Proposed Design - Pre-Application Feedback

A Pre-Application enquiry (23//0032/PREAPP) of an earlier design iteration which had a larger footprint on site and was closer to its boundaries was submitted on 11/04/23. The present proposals have responded to each of the feedback points noted below. The key changes have also been shown in annotation on the layout diagram on page 29.

Part 1 of feedback received by email on 02/08/23:

Part 2 of feedback received by email on 22/08/23:

Proposed North and South Elevations (with Existing)	
SCALE ISSUED AT 1:100 @ A1 1:200 @ A3	DATE 19/03/2024
DRAWING NO. 222.34.31002.ELE	REVISION P1

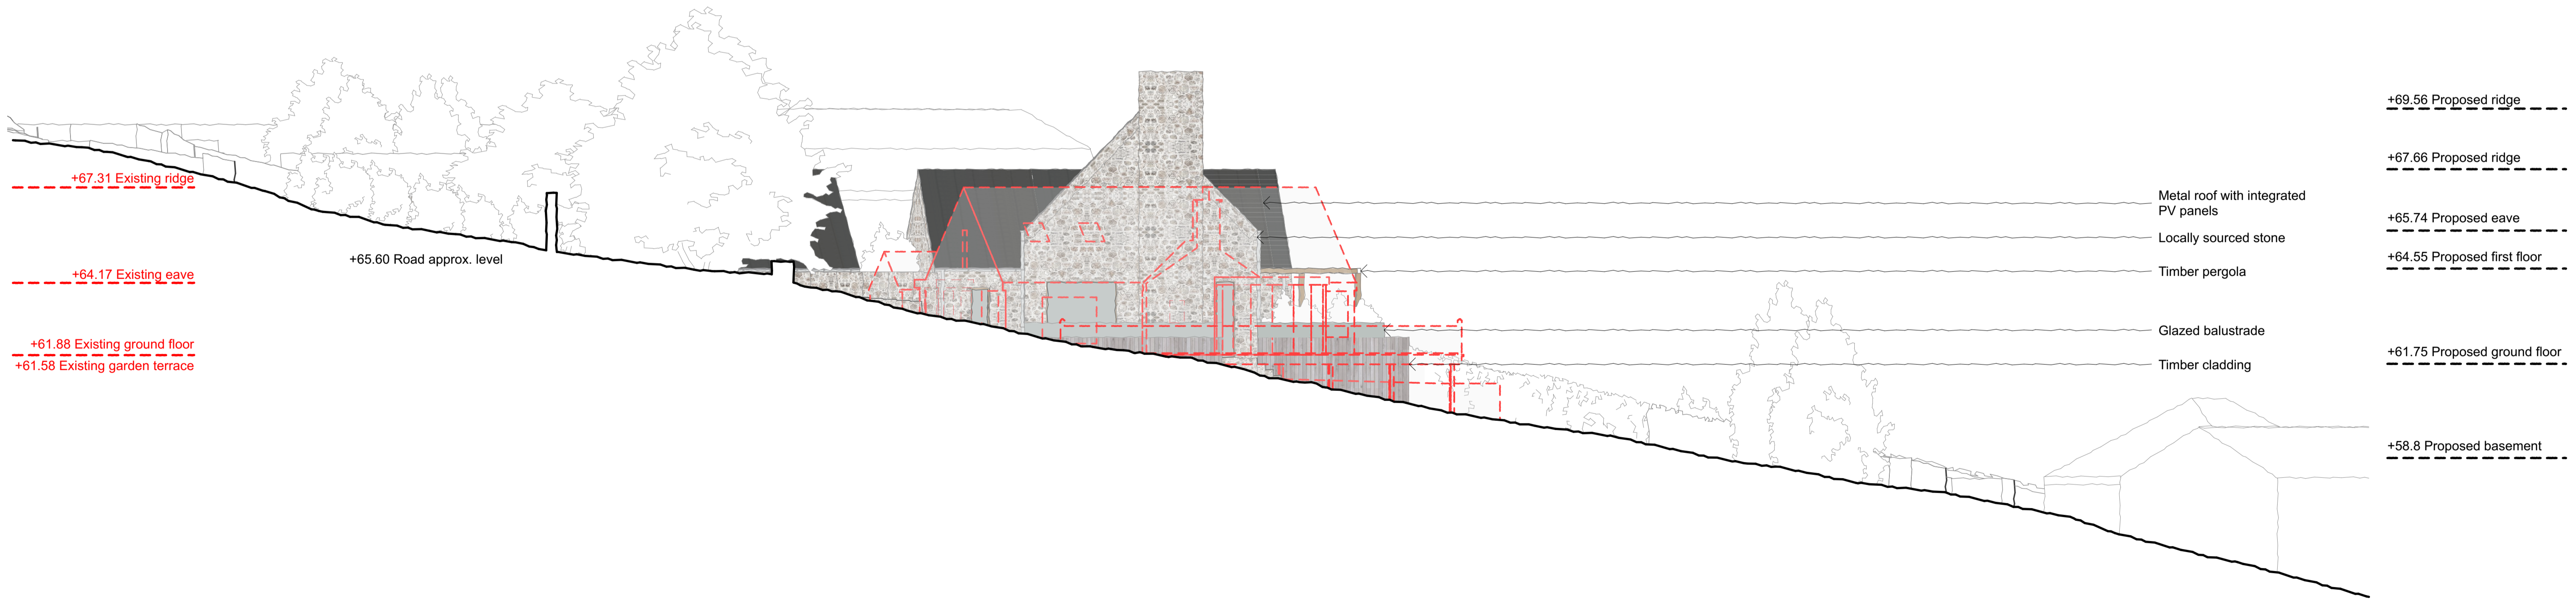
Clarification was sought over the potential for impacts on the privacy of neighbouring dwellings in relation to overlooking into dwellings and private areas of gardens. Clarification/information was sought on window positions and the terrace/balcony, site levels and between existing and proposed.

- An indication of which windows of the proposed dwelling will be obscure glazed;
- Scaled elevation plans of the proposed dwelling which include an indication of its floor and terrace levels (e.g. with dashed lines and including the absolute level figure) and which have the elevations of the existing dwelling superimposed on them (e.g. in colour) including its floor levels and the position of its windows and decking/terrace areas, for comparison purposes;

- A section approximately north-south through the proposed dwelling showing existing and proposed ground and floor levels, existing and proposed window levels, the heights of boundary treatments and the outlines of neighbouring dwellings (as far as this is possible);

The proposed garden level terrace has been excavated into the existing slope of the garden, meaning that the potential for overlooking from this point is less than existing. Only one small obscured window (from a shower room) is proposed to the northern elevation so as to prevent any overlooking of Bera Watch.

The height of the ground floor windows on the proposed Southern Elevation are in-keeping with those on existing building. Increased planting along the sites southern boundary will enhance privacy but is not essential given the topography, existing boundary hedge and trees and the orientation. The only neighbouring window that is located within 20m of the proposals windows is Southdowns first floor north-facing bedroom window (approx. 17m away), which currently overlooks the Sea Chimneys site and is substantially screened by the present hedge. Views between this window and the proposals ground floor south-facing windows will be carefully prevented by bolstering the existing planting along the sites boundaries.

DRAWING DETAILS  
Proposed East and West Elevations

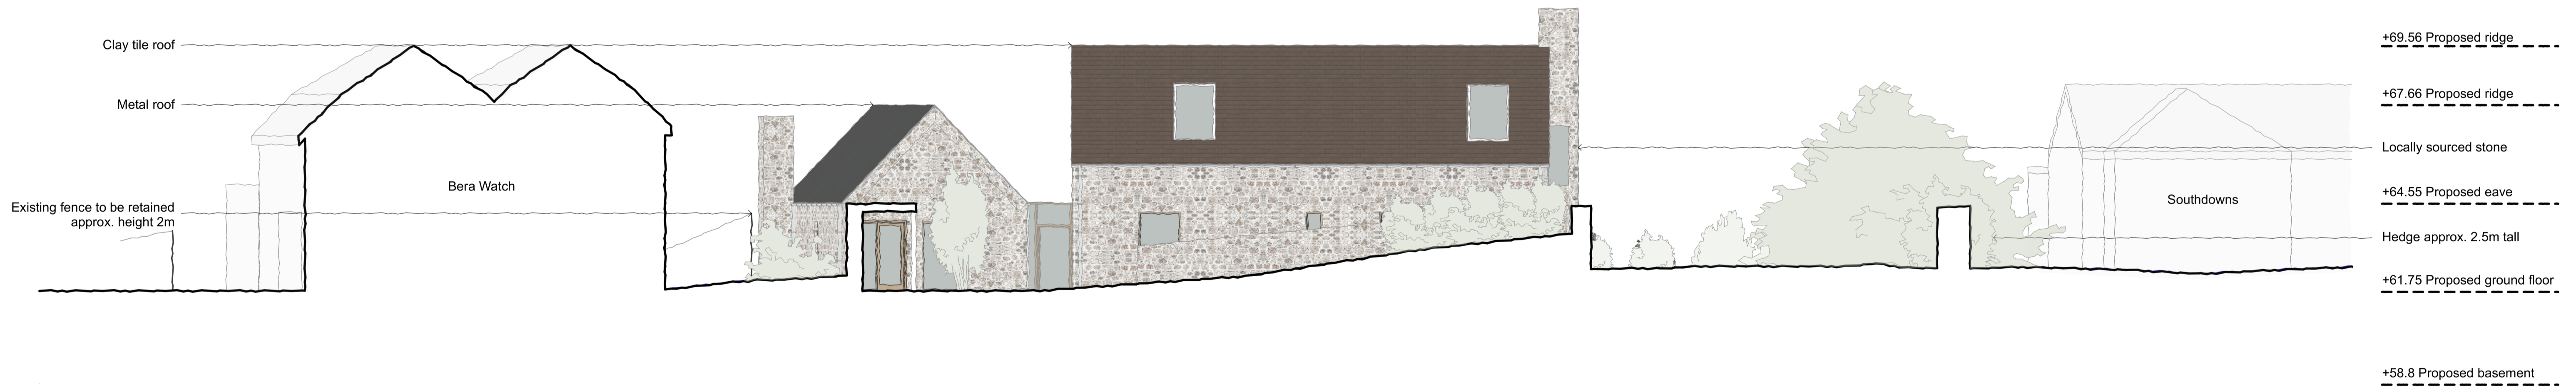
Sections east-west showing the relationship with the outlook of Bali Hai and Crabtree were requested.

It was noted that the proposed development would involve the replacement of a chalet bungalow with a three storey dwelling partly set into the ground. The site occupies a hillside position and is visible from many surrounding viewpoints and the proposed dwelling would be higher than the neighbouring dwellings to the north and south. Hence further clarification was sought over the scale and massing relative to neighbouring property in long views and of the absolute height relative to neighbours.

11. The proposal has been scaled down to ensure it is in-keeping with the surrounding properties

The proposal will be visible from certain points along the footpath that runs along the eastern edge of the site. The design and scale of the proposal has been reviewed to ensure it is in-keeping with the neighbouring properties at the same elevation. The proposed ridge height matches that of Bera Watch. The proposal will be in keeping with its neighbouring properties when viewed from the PRoW. Sea Chimneys will not be visible from the PRoW when it reaches the bottom of the site. The tall perimeter hedgerow, which is to be retained at its existing height blocks views of the proposal from this section.

DRAWING DETAILS	
Proposed Long Section	
SCALE ISSUED AT 1:100 @ A1 1:200 @ A3	DATE 19/03/2024
DRAWING NO. 222.34.41005.SEC	REVISION P1

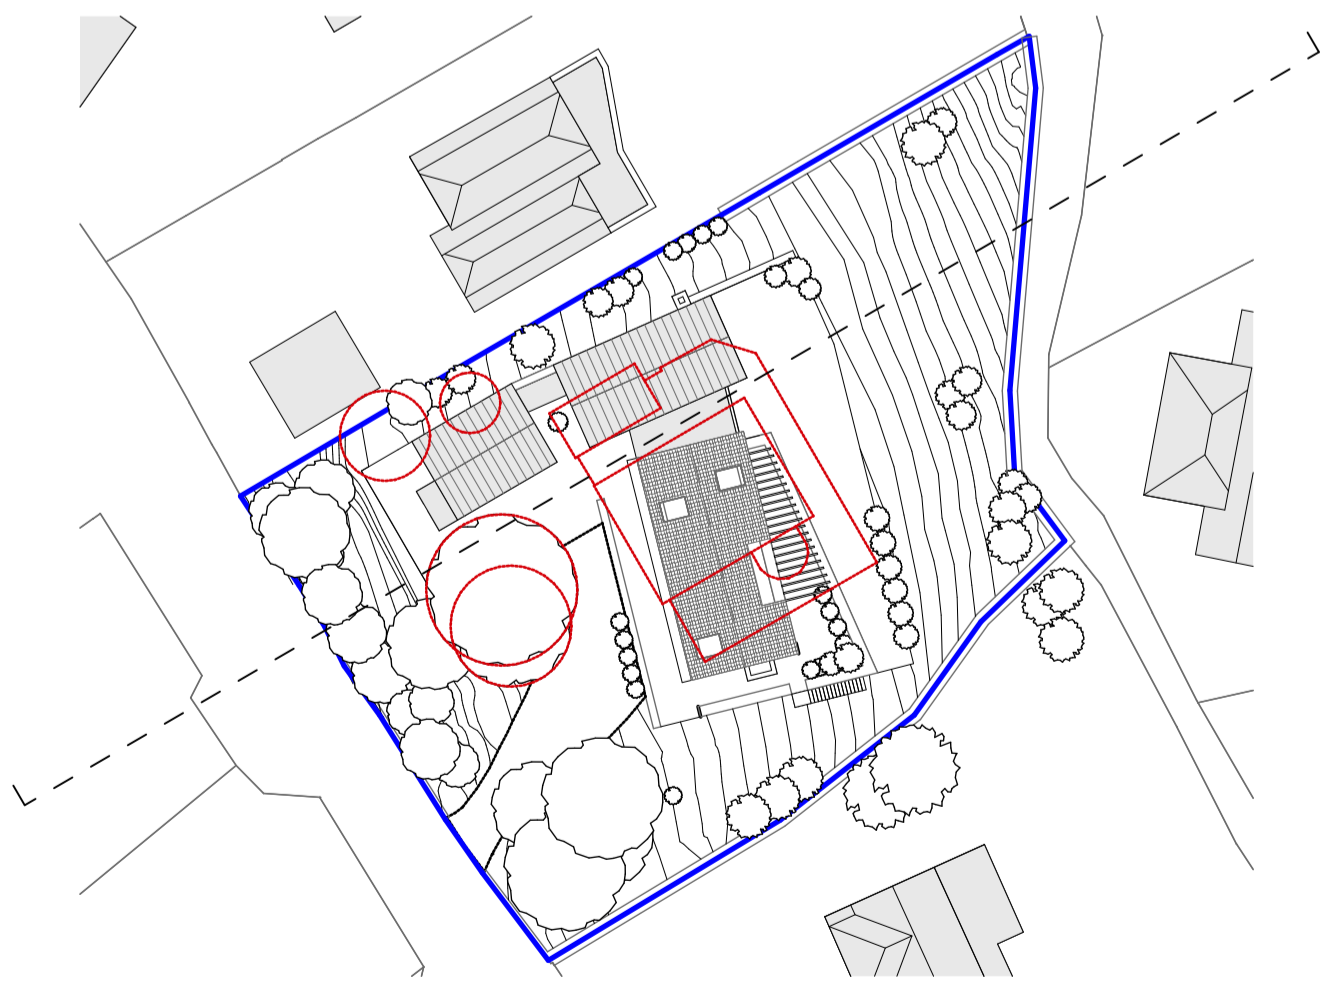
As the proposed 2-storey dwelling would be located close to the southern side of Bera Watch and would have a different form and footprint to the existing dwelling, a comparison for sunlight/daylight reaching that dwelling and its garden was requested.

The proposals have been carefully designed to avoid any increase in overlooking from the present situation. The proposal leaves space around the sites boundaries and is orientated to look down the length of the garden. The level of the ground floor is below that of the existing house and garden terrace. Additional planting has been incorporated on the south-eastern corner of the proposed ground floor garden terrace, to enhance privacy. The tall hedge on the eastern boundary of the site will be retained to maintain present relationships and ensure any overlooking into gardens further down the hill will be prevented.
